Arun District Council  
Arun Civic Centre  
Maltravers Road  
Littlehampton  
West Sussex BN17 5LF  
Planning & Building Control General Enquiries  
Tel: (01903) 737756 Fax: (01903) 730442  
Dx: 57406 Littlehampton  
Minicom: 01903 732765  
e-mail: [planning@arun.gov.uk](mailto:planning@arun.gov.uk)  
website: [www.arun.gov.uk/planning](http://www.arun.gov.uk/planning)

Application No: BR/94/22/HH  
Site Address: 38 Bassett Road Bognor Regis PO21 2JH  
Description of works: Roof extension to create 2 additional annex including the installation of 4 x dormers and balcony and alterations to fenestration/openings.

Thank you for your internet representation made on 30th May 2022 which has been recorded as an objection with the comments as follows:

Proposed First Floor Plan

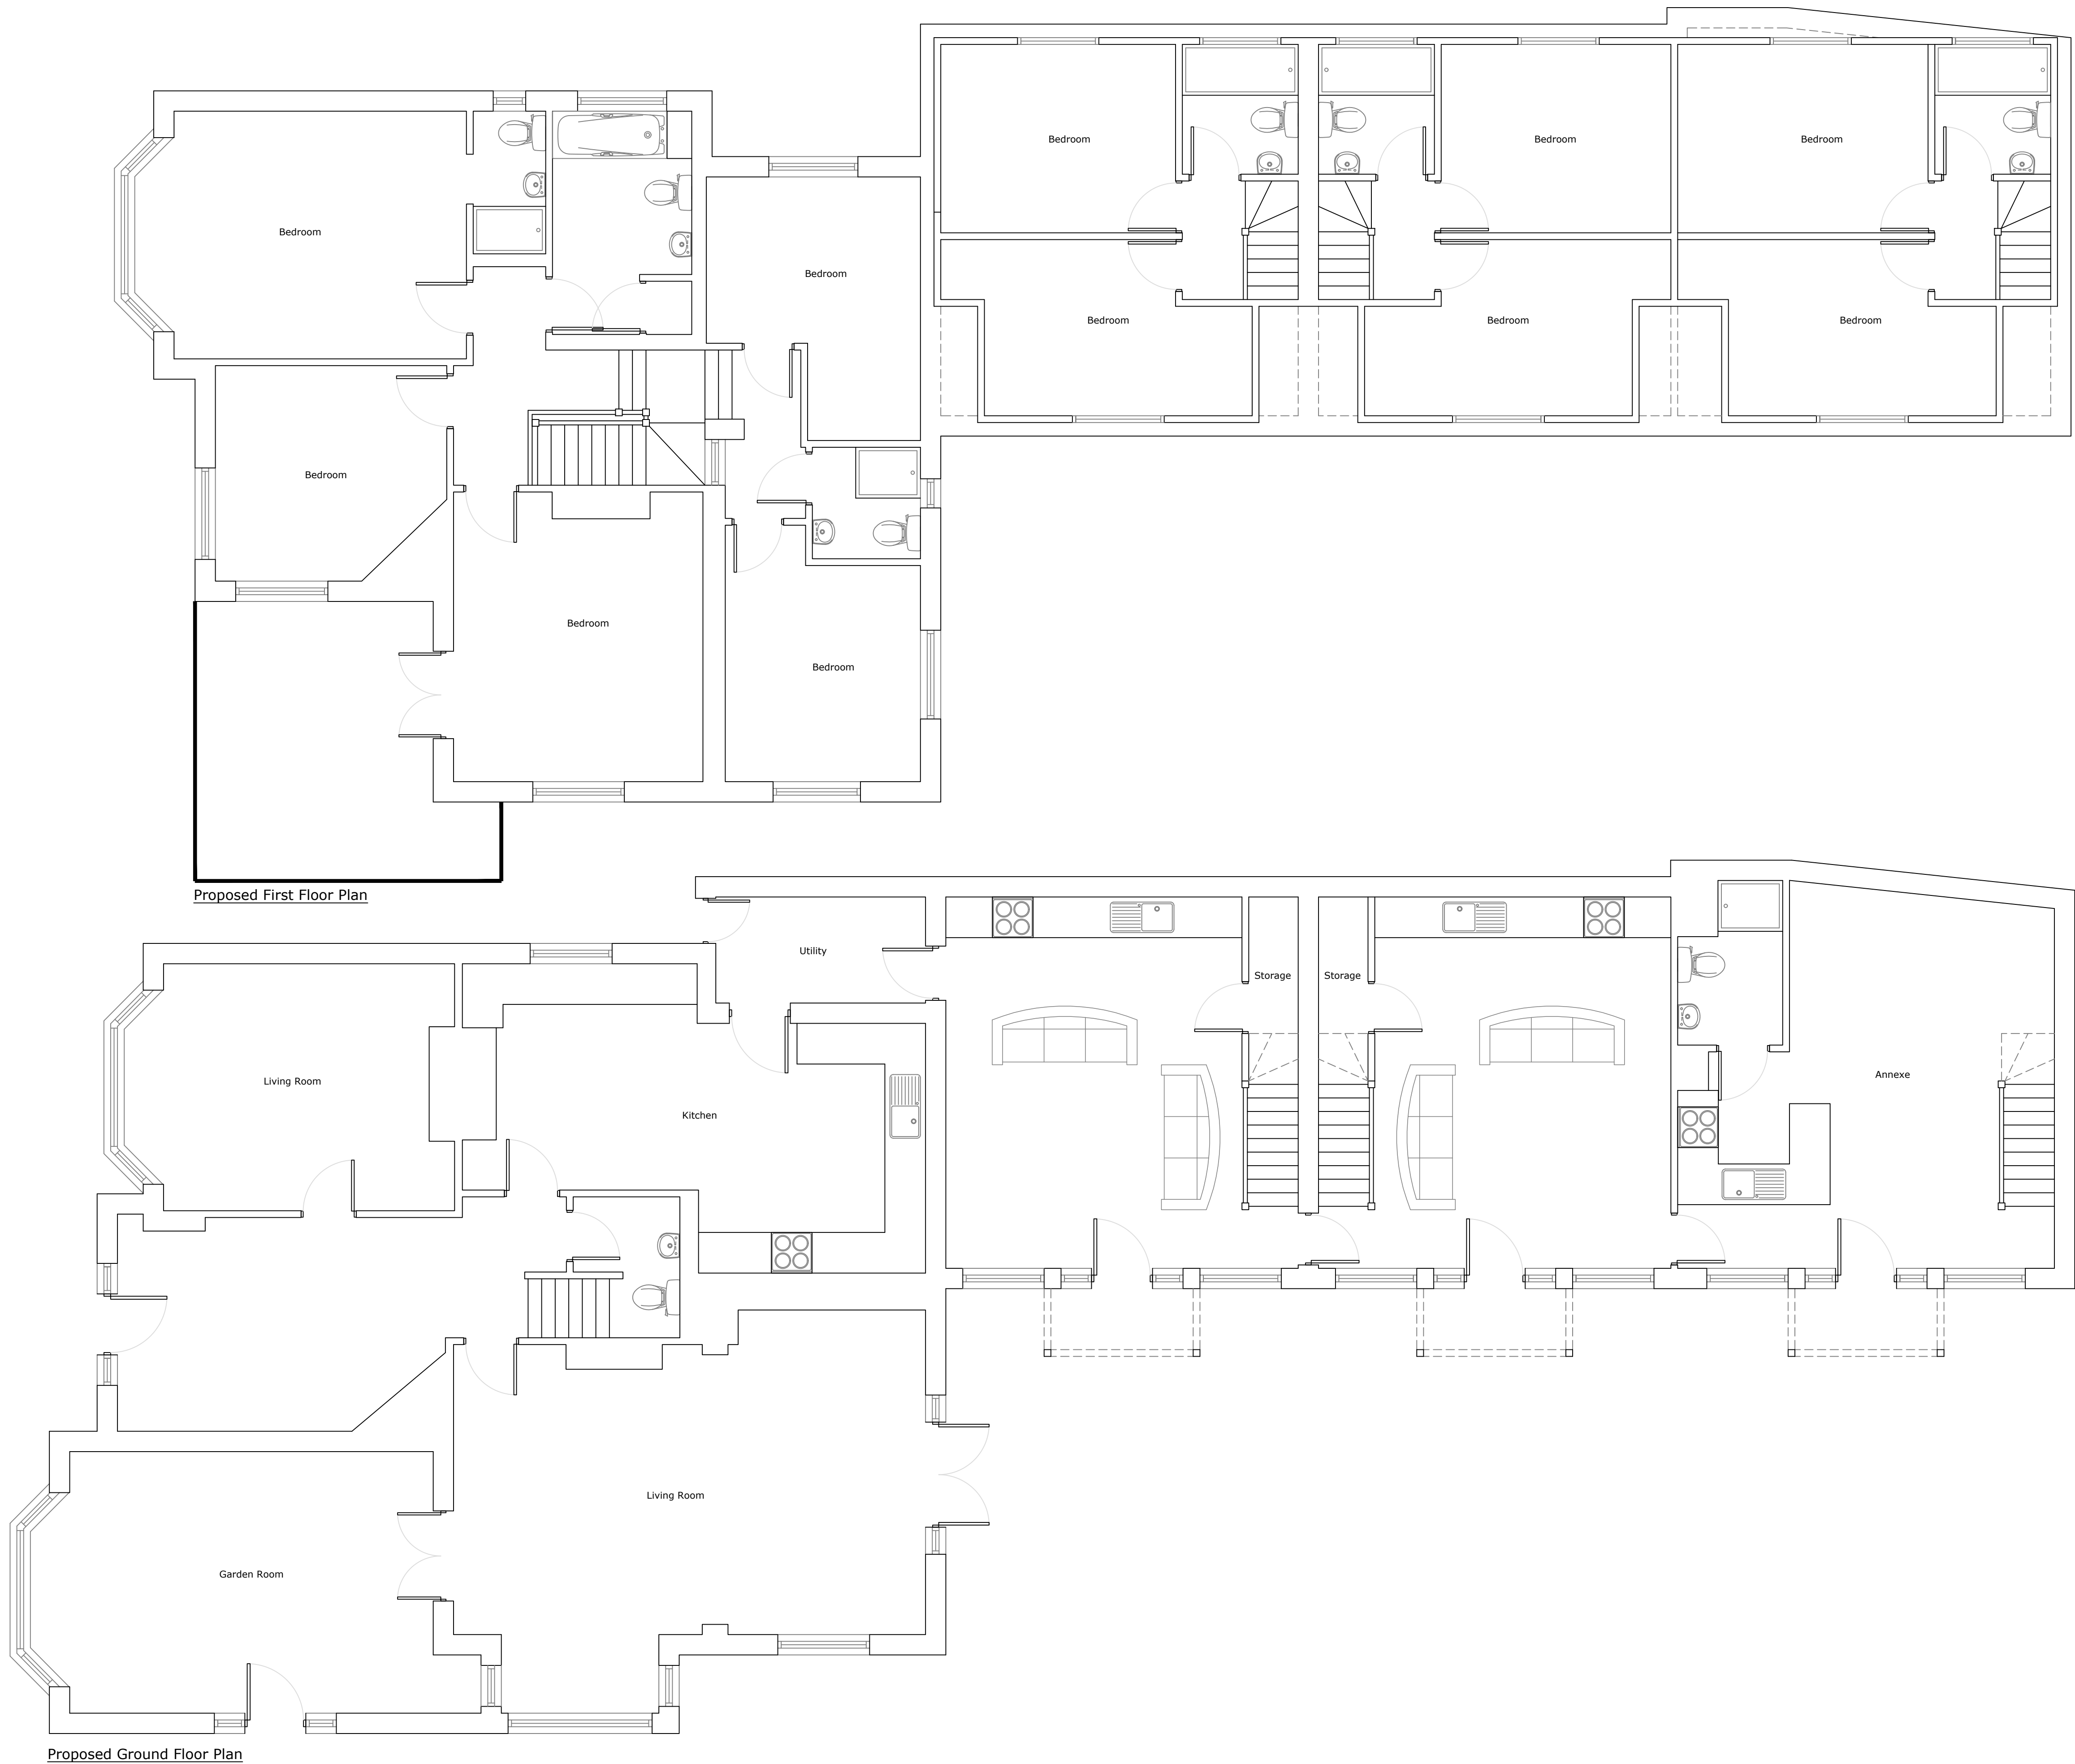
1. It states the proposed building extension is for 'Family Members only.' I believe this not to be the case based on the proposed plans. The Floor plans show potential for 5 self-contained living spaces that could be adapted due to the adjoining internal doors. I firmly believe this to be a business venture with holiday letting as the primary intention.

8. In the written description of the proposed plans it states there are only two dormer windows where in fact there are three.
9. Within the proposed plans, there is another front door to the main part of the property. The plans are not clear on what the intentions are for that part of the building.

10. The existing part of the property that contains a swimming pool, would have a complete change of use. Looking at the proposed plan for the three downstairs living spaces there is only the front door as a means of escape, so do not believe this to meet current fire regulations, especially if this was to be used other than for family members.

Proposed West Elevation

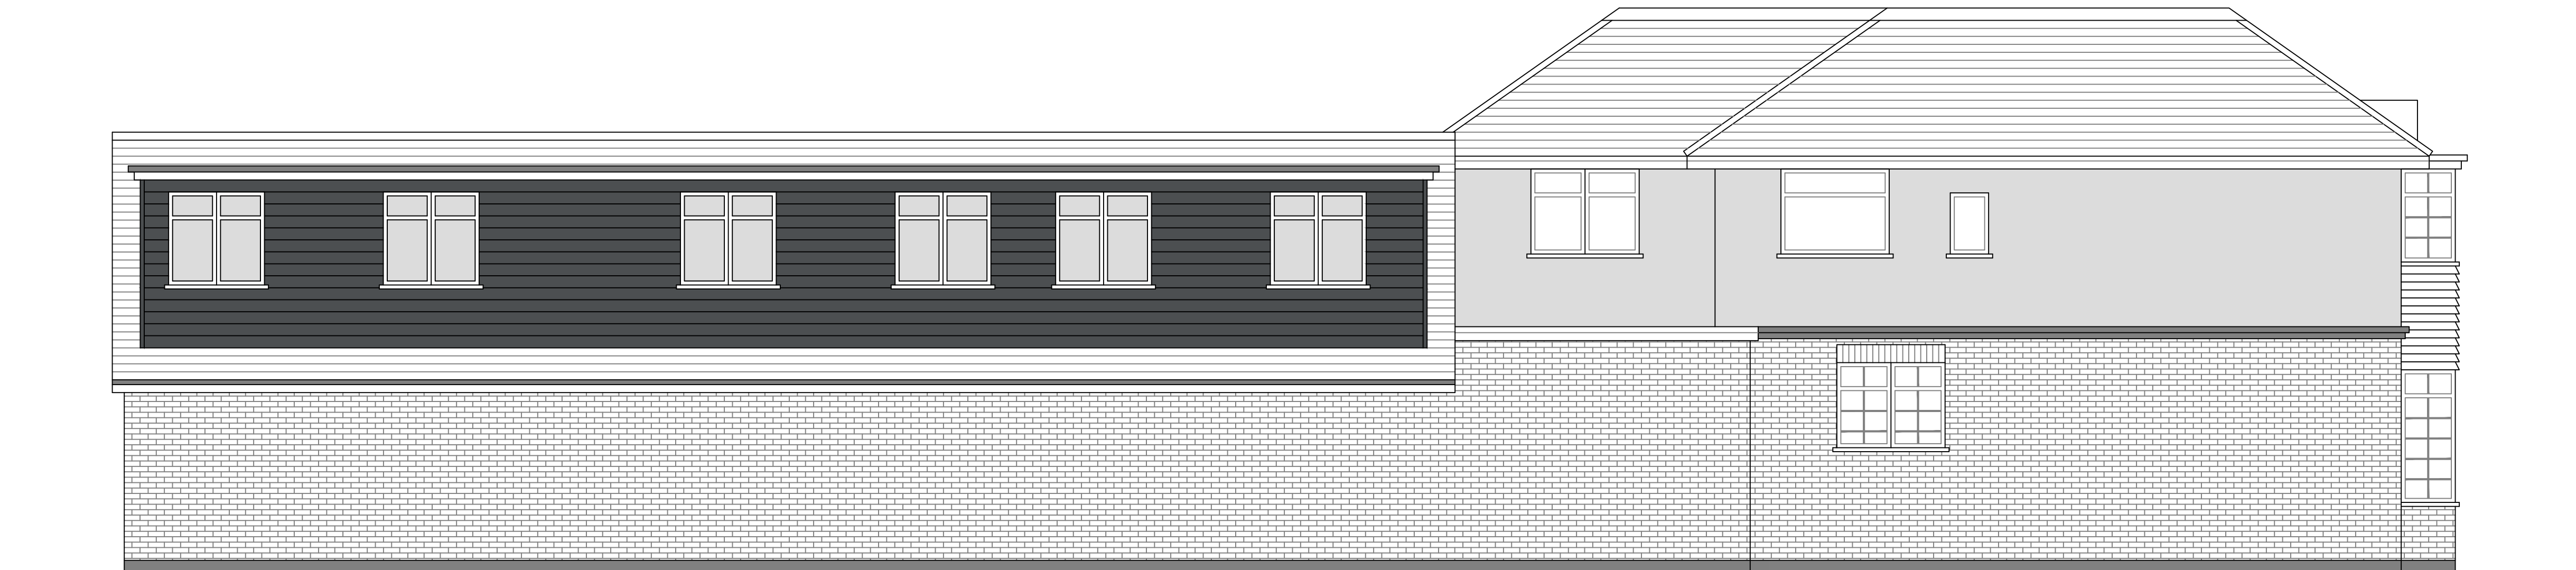
5. I believe the proposed plan will have a negative effect to the appearance of the local area as this development can be seen from the public footpath and highway. With the proposed extended height of the single storey building, it would reduce light to neighbouring properties

6. With the proposed balcony to the front of the property, this would have a direct negative impact to our privacy, especially being at the same height as our 3-bedroom windows
